**Consultation Response from KC,
Highways Development Management****2024/92075 2 A, East Bath Street, Batley, WF17 5NP****Demolition of existing dwelling and erection of two detached dwellings****Date Responded: 11-20-2025.****Responding Officer: Mark Berry.****Responding Ref: 123-10SE-18.**

This application seeks approval to the demolition of an existing bungalow and erection of two detached dwellings at 2 A, East Bath Street, Batley.

Ground Floor Plan
PLOT 2

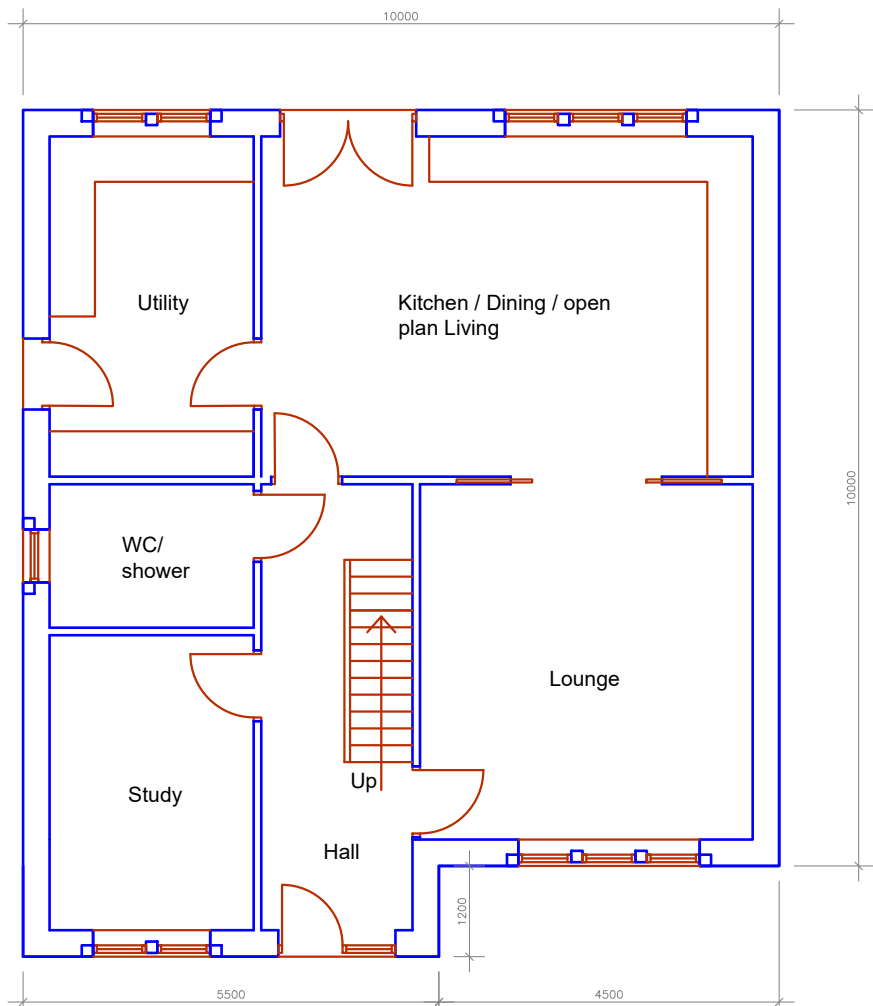
1, Plot 2 is a 4 bedroomed house with just 2 off-street parking spaces. The recommend parking standards for a 4 bedroomed house is 3 spaces.

**DRG:**  
PROPOSED SITE PLAN

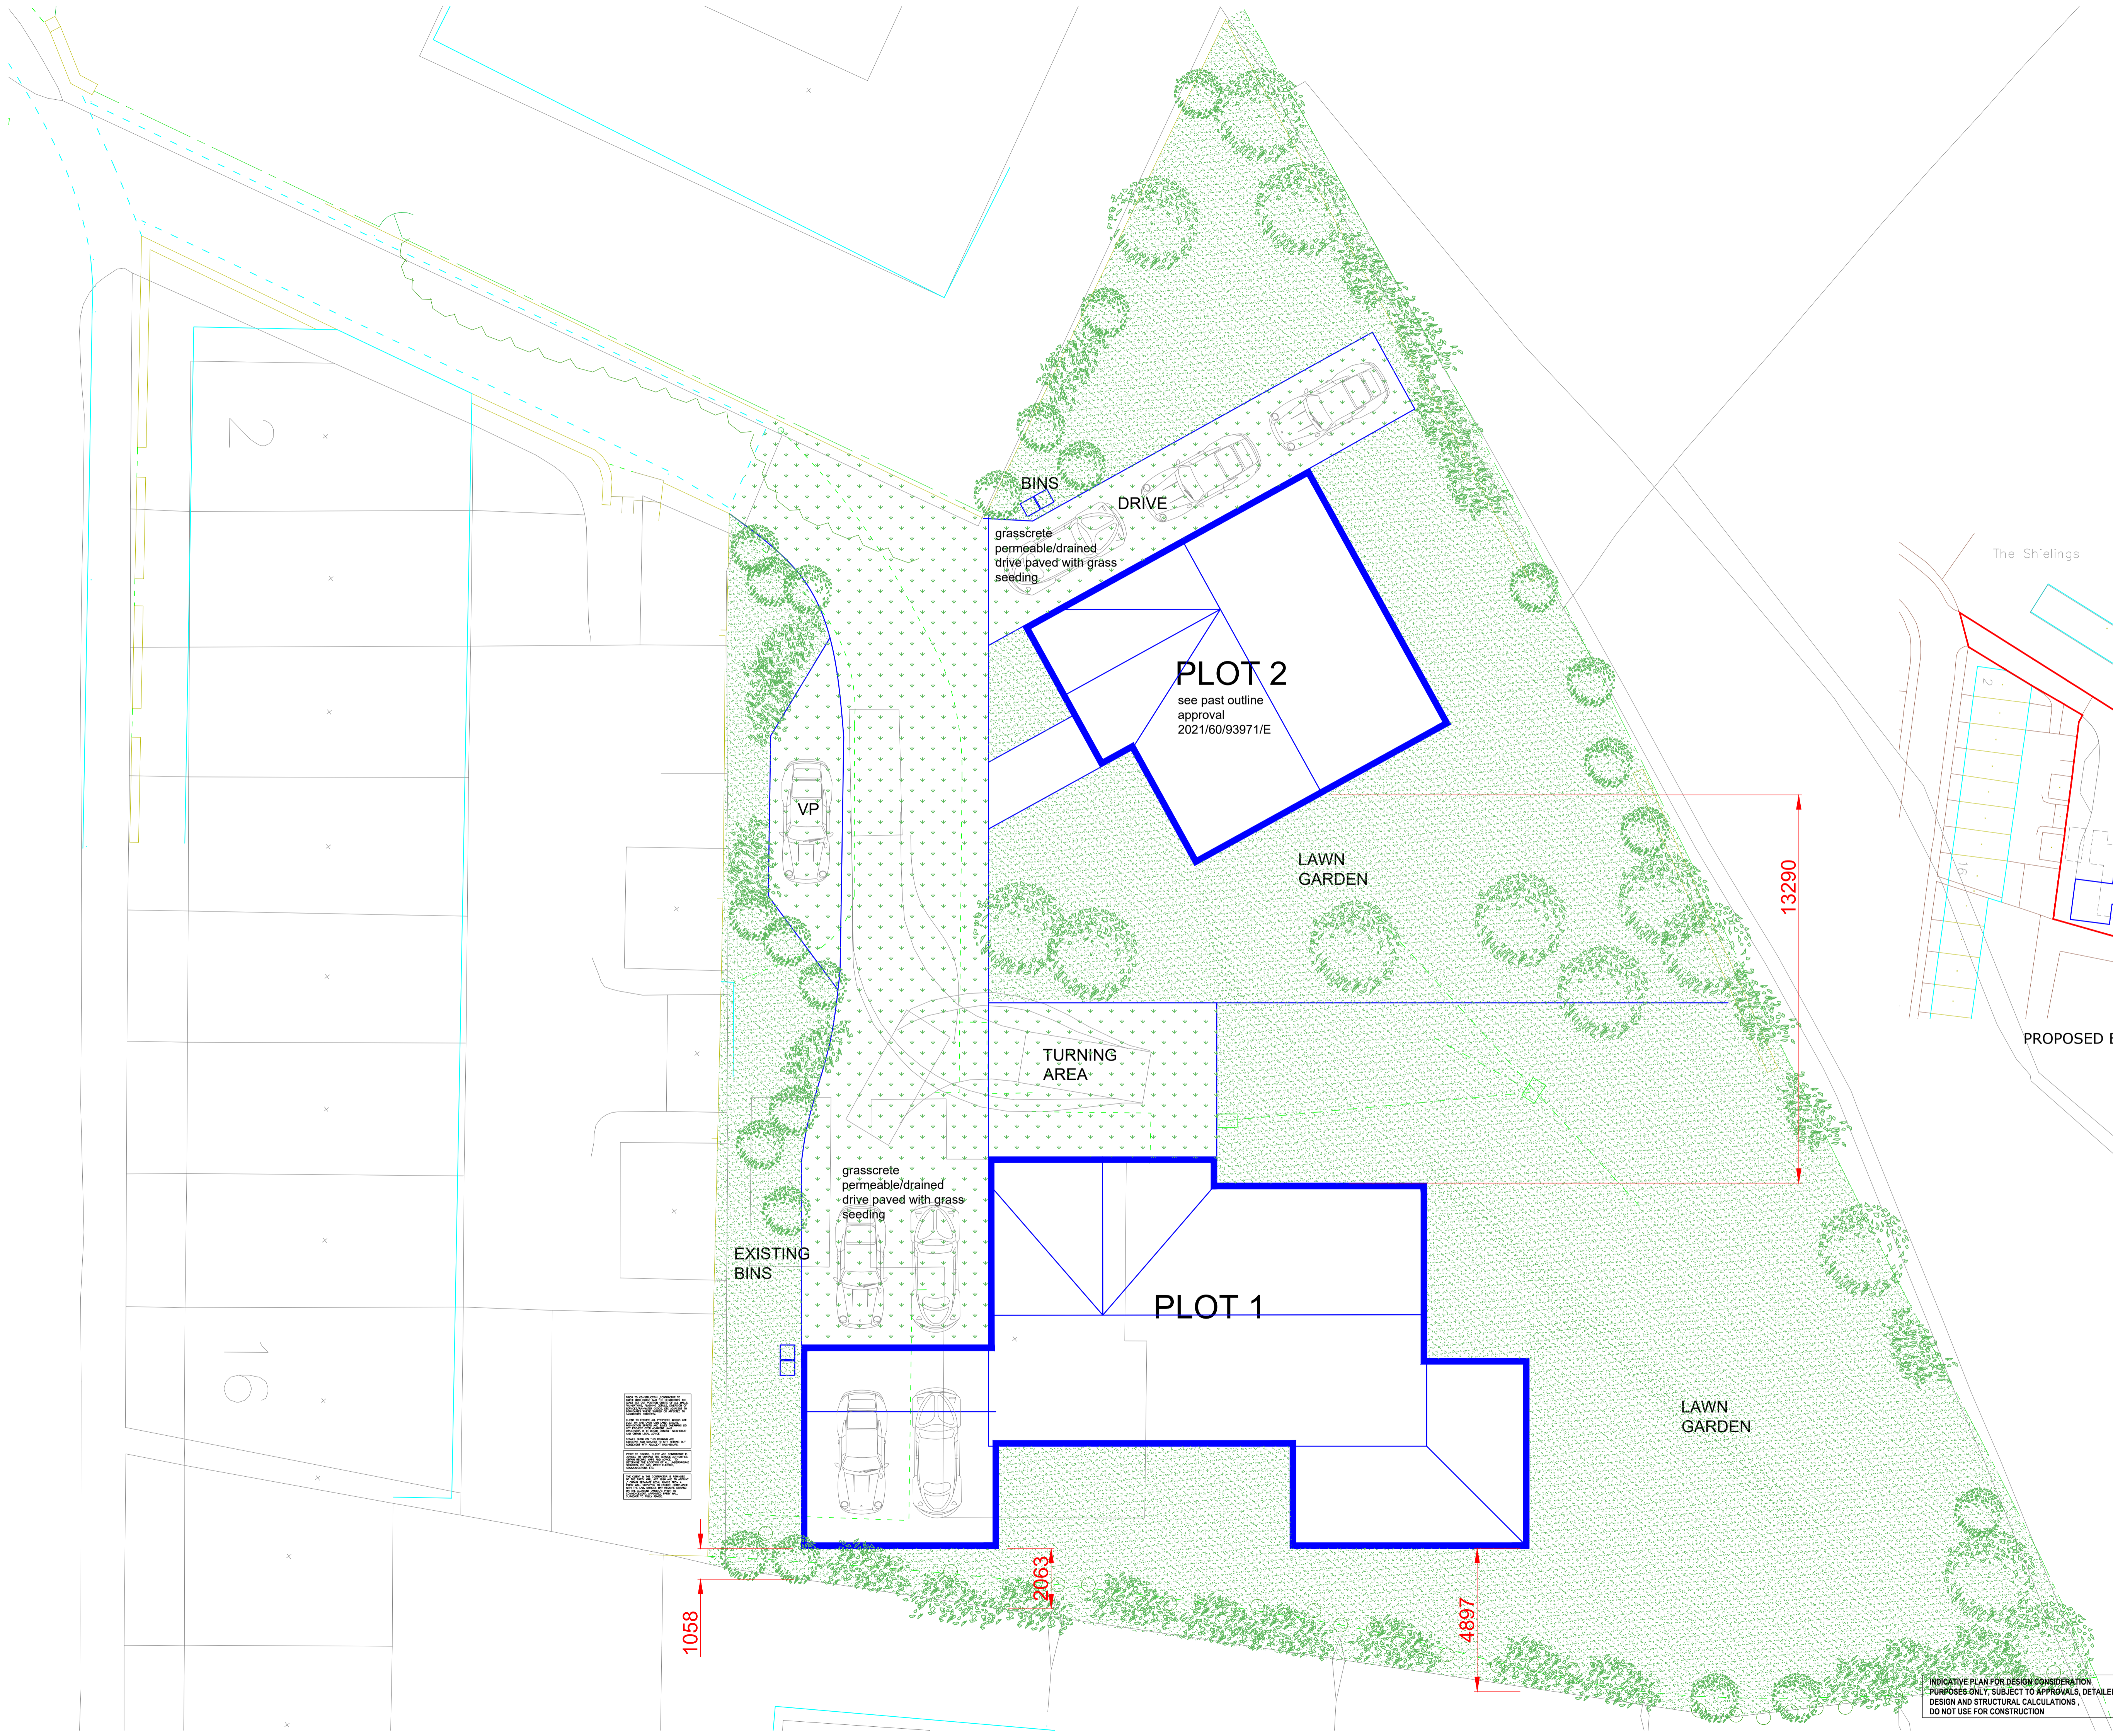
No information is provided to demonstrate that an emergency vehicle can enter, exit, and turn within the site.

Plot 1 is over 45 metres from the access from East Bath Street and emergency vehicle access and turning should therefore be shown provided.

there should be a minimum carriageway width of 3.7 m between kerbs.

there should be vehicle access for a pump appliance within 45 m of single-family houses.

fire service vehicles should not have to reverse more than 20 m.
